Letter No. **A1/22580/91**

Sub: **MMDA - Planning Permission - Construction of GP residential building in Plot No.29A at S.No.255/1C of Perungalathur village - Approved - Regarding.**

SITE PLAN

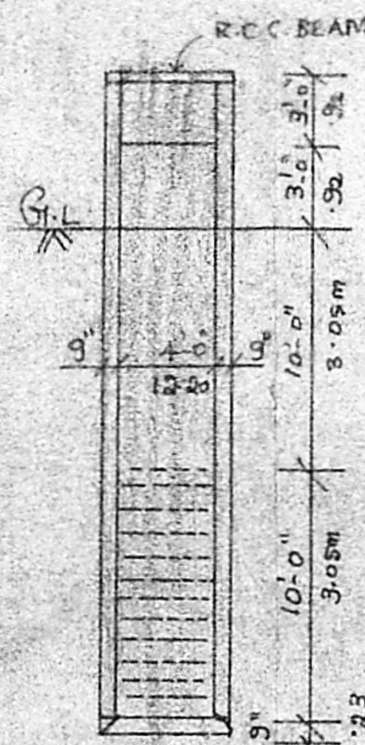
towards Regularisation charge by two separate Demand Drafts of a Nationalised Bank in Madras City drawn in favour of the Member-Secretary, MMDA., Madras-8 or in cash/and pay at MMDA. office Cash Counter between 10.00 A.M. and 4.00 P.M. within 10 days and after remit the said amount, you are requested to remit the duplicate receipt to Area Plans Unit. You are also requested to submit the Affidavit for ULC in Rs.5/- Stamp paper duly attested by Notary Public. Planning Permission Application will be returned unapproved if the amount are not paid within the stipulated time. You are also requested to furnish 5 sets of revised plan showing the splay as 1.50 x 1.59mts.
